Subject: RE: Planning Consultation on: FG/95/20/DOC

Comments in respect to surface water drainage (Condition no.3);

Application No: FG/95/20/DOC
Registered: 14th August 2020
Site Address: Elm Lodge Tamarisk Way Ferring BN12 5ER
Description of Works: Approval of details reserved by condition imposed under APP/C3810/W/20/3245781 (FG/141/19/PL) relating to Condition Nos 3 - surface water drainage, 6 - obscured glazing, 7 - external lighting and 8 - landscaping.

Infiltration Basin Structure

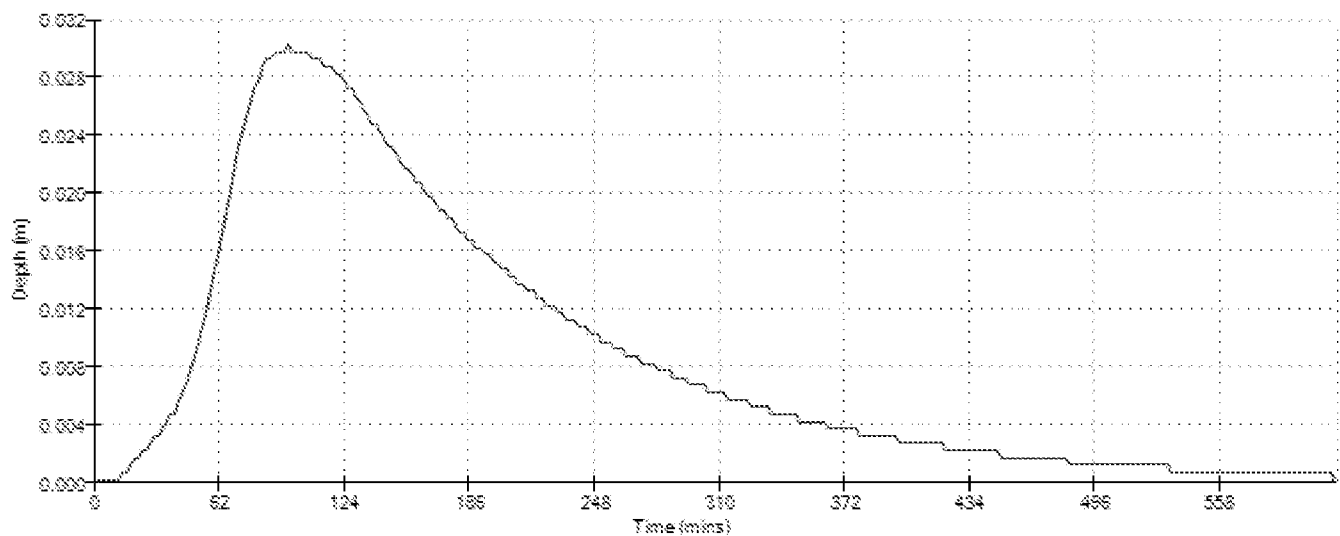
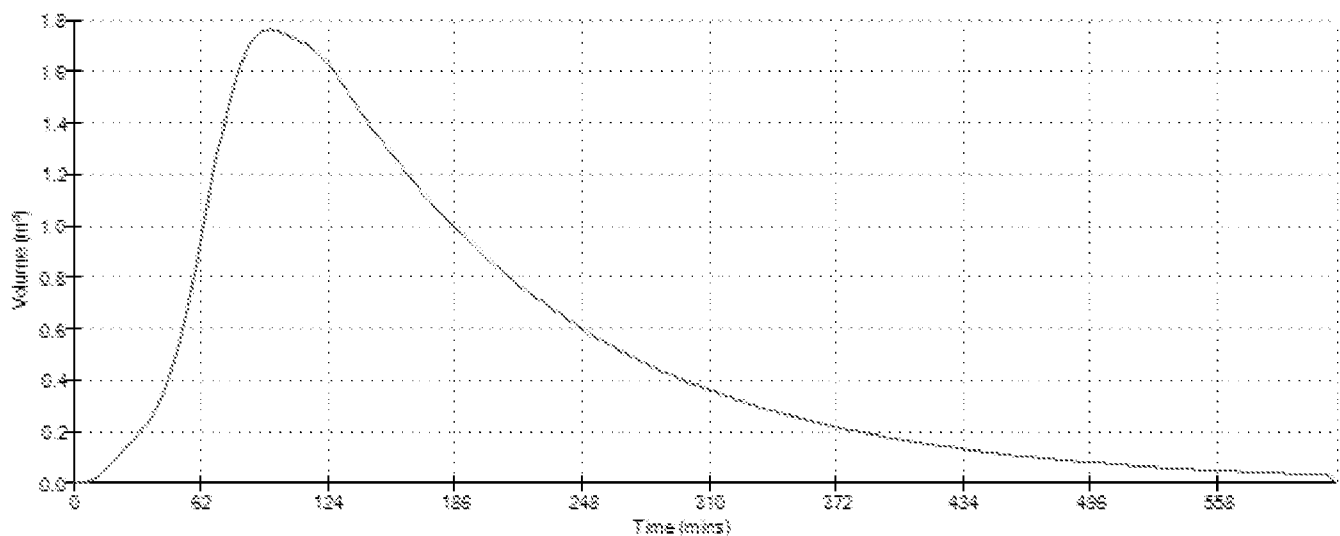
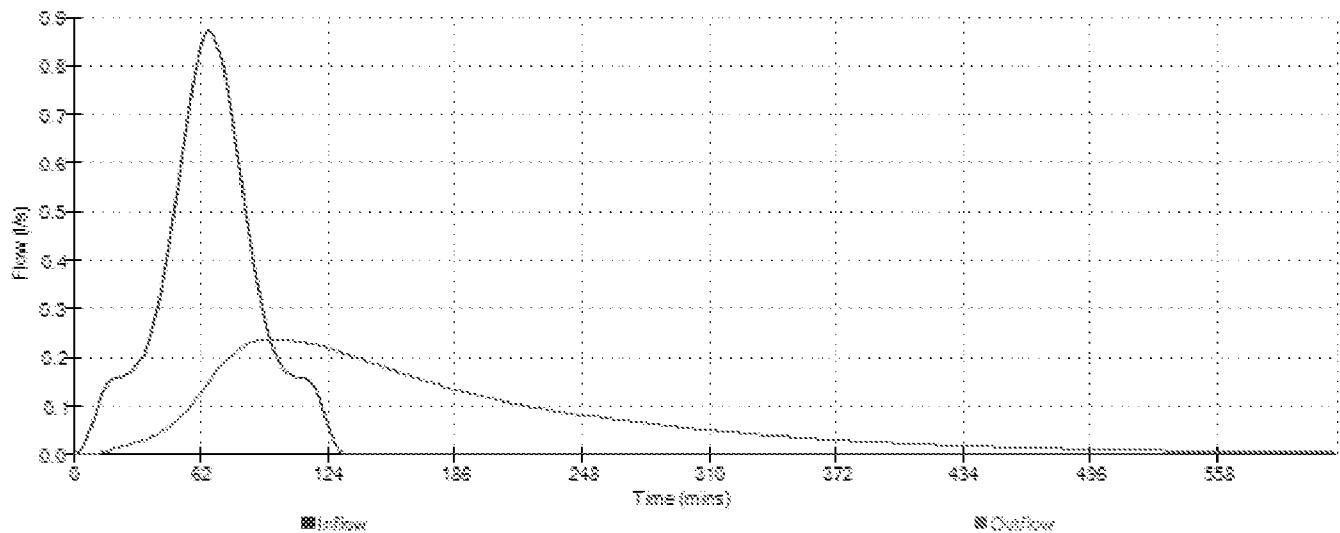
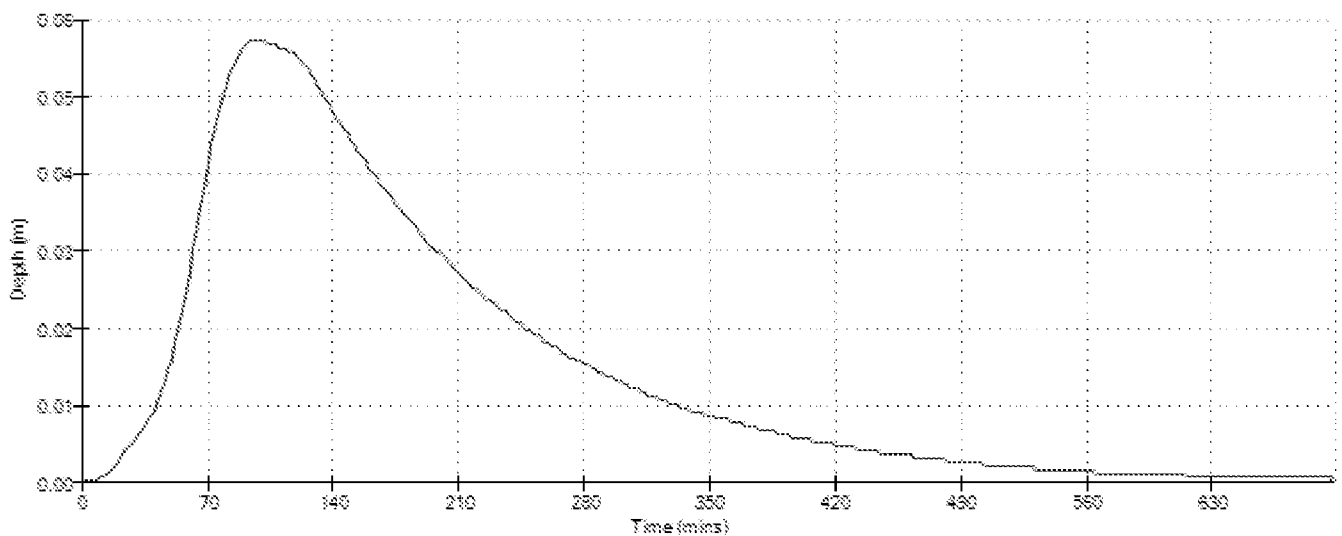
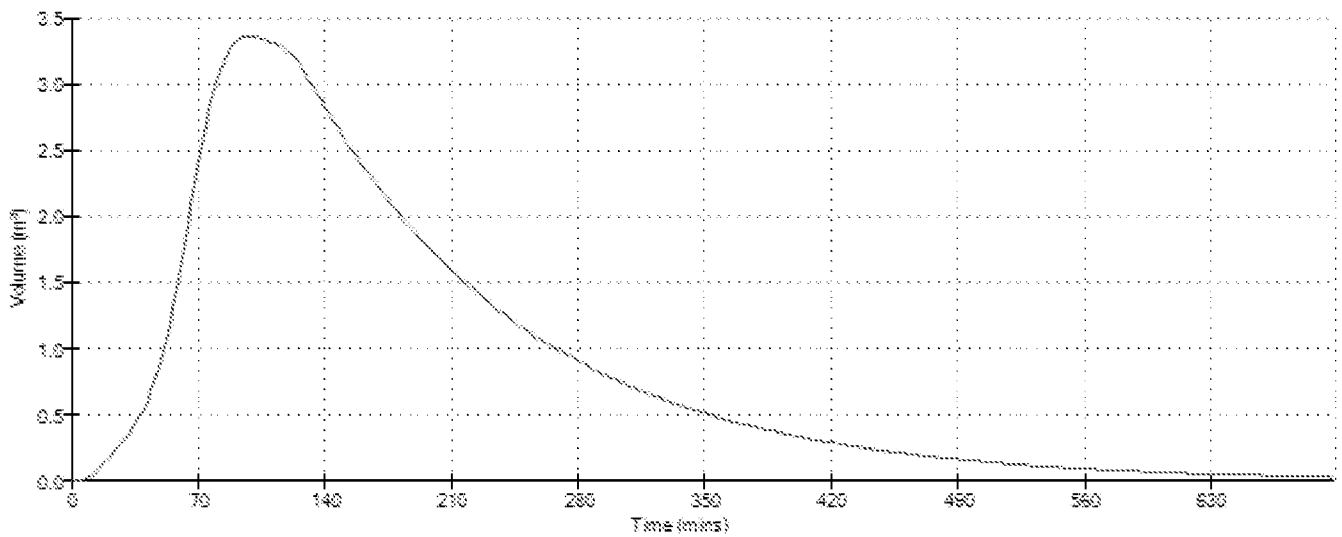
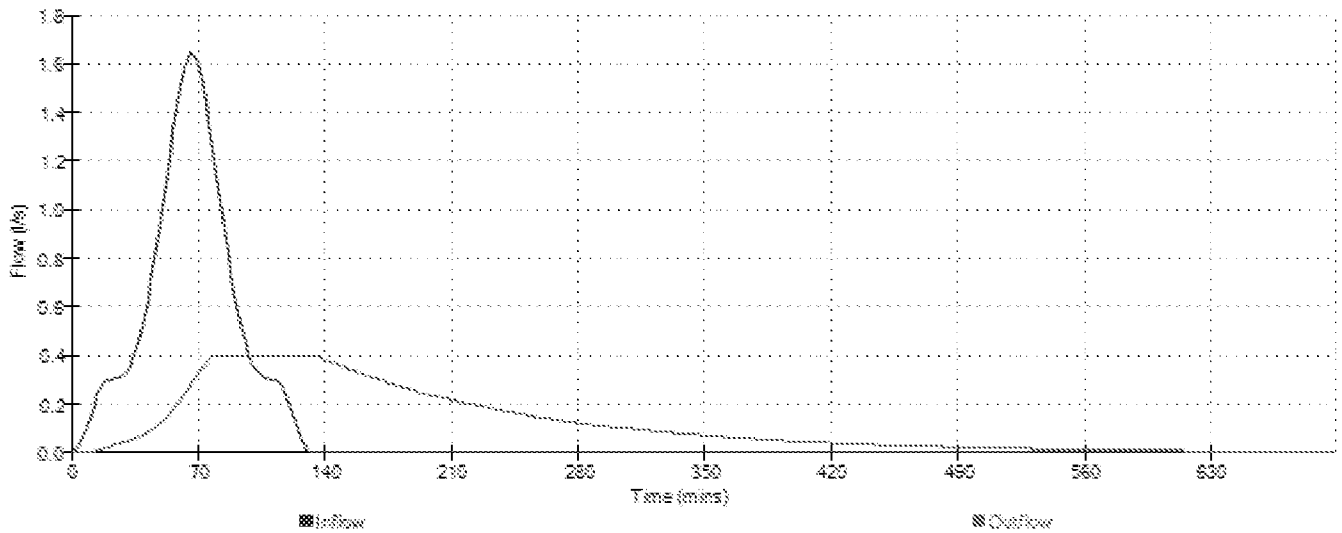
1. The proposal to connect surface water drainage directly into the pond would not be acceptable as the infiltration design is compromised by peak groundwater levels, etc.

3. To achieve a suitable solution, roof water will need to discharge to crate soakaway/s, ensuring the base level is above 5.05m AOD (the highest recorded groundwater level). Soakaway structures need to be kept 5m from any building. The most suitable location for a soakaway in the area of the assumed existing soakaway (north west area of plot), but will need to take account of the culvert mentioned below. Infiltration testing should be carried out at the location of the proposed structure, at the depth of the structure/above peak recorded groundwater levels and the worst recorded rates used. The nearest test pit is located in the pond area due east. Since the testing was undertaken at a different location to the likely soakaway location and at a depth slightly below peak recorded groundwater levels/not at potential base level of the structure, the data is not fully trustworthy for the design. Due to these circumstances, there are two options;

- A) Undertake further infiltration testing at an agreed time this coming winter at the location/depth of the proposed soakaway, in strict accordance with BRE365 and rework the design accordingly.

- B) Design a shallow crate storage structure with its base above 5.05m AOD with a restricted outflow to the pond or culvert depending on its flow direction (discharge rate to be agreed). The system will need to accommodate the 1 in 100 year (+40%) storm event and any flow control aperture protected from blockage. Silt traps also to be provided upstream. It would need to be constructed/detailed to allow for maximum infiltration potential but the infiltration not accounted for in the calculations. This option should be considered a compromise.

Porous Car Park Structure

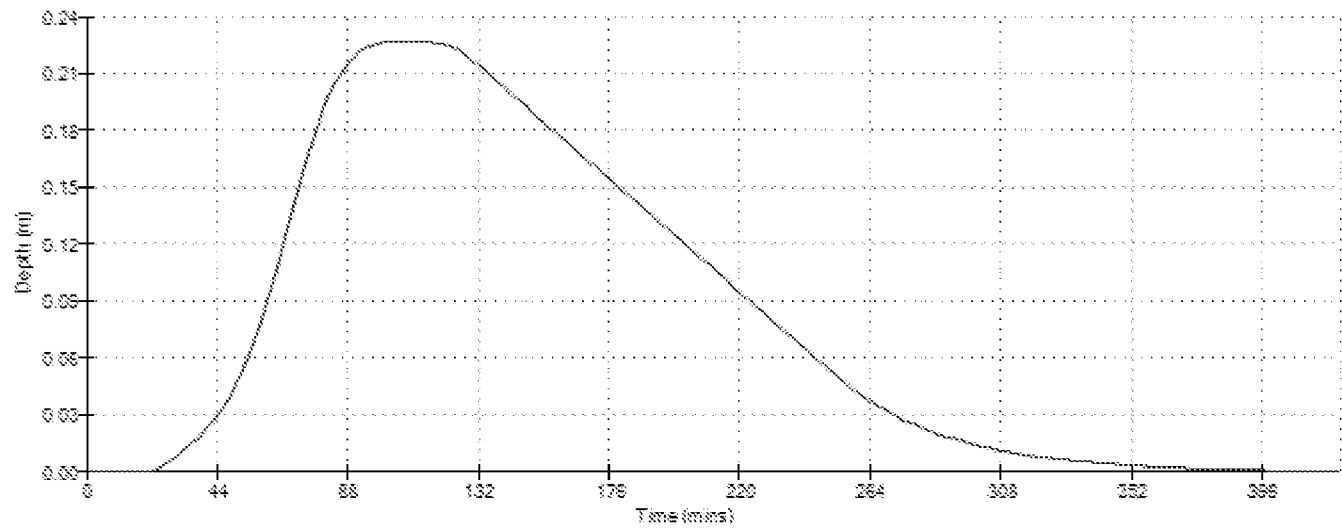
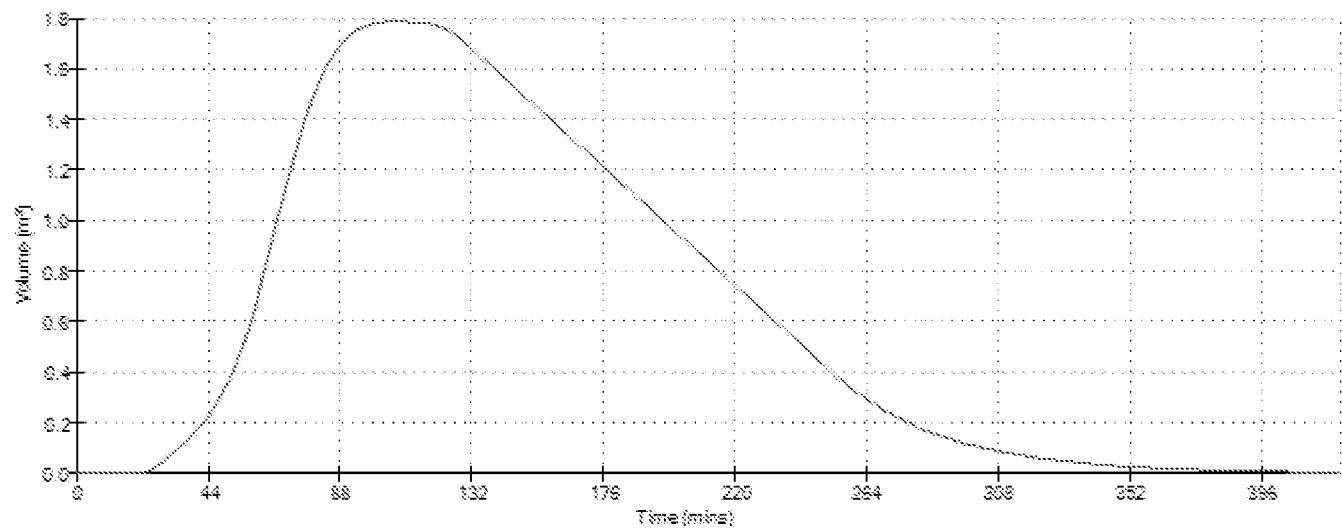
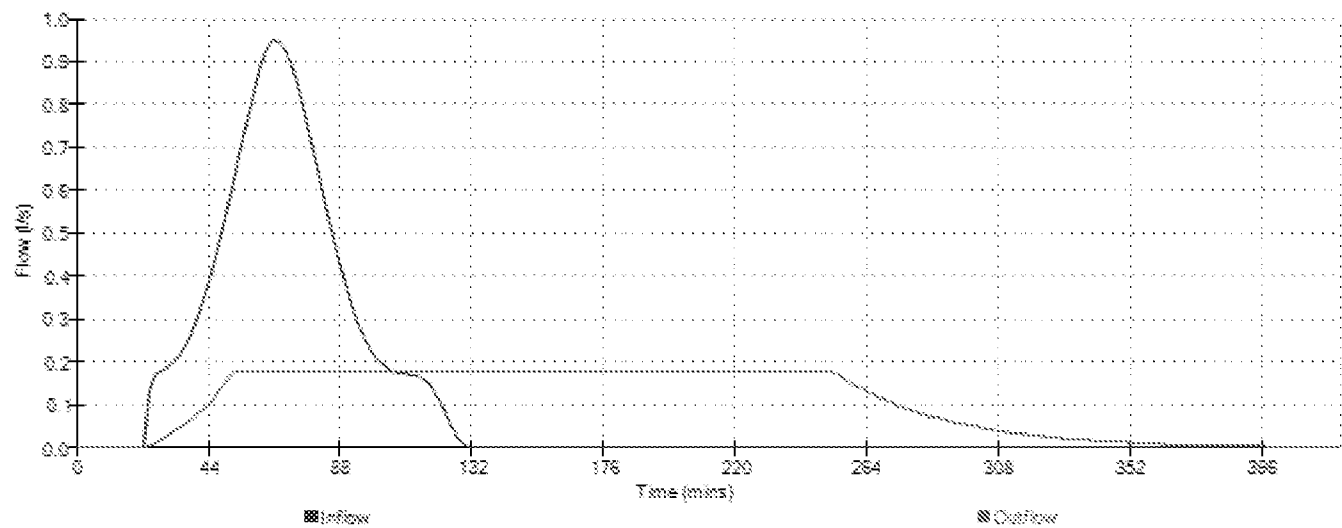
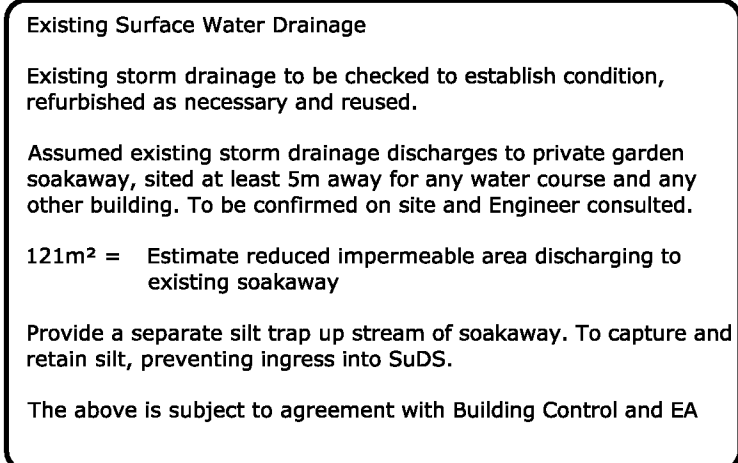
4. Permeable paving – again the infiltration testing was not carried out in accordance with BRE365. However, in this instance, I would suggest that the results from test pit 2 are recalculated into an infiltration rate using BRE365 methodology (assuming there is suitable raw data available from the testing). Using the worst rate achieved ie. from the third test, provide amended hydraulic calculations. The structure will act as a standalone soakage structure. Please amend the construction detail accordingly, making it clear that the sub base will be fully wrapped in a permeable geotextile. Base levels should also be stipulated on the plan. Please note that the construction detail currently species 'No infiltration' so needs to be adjusted.
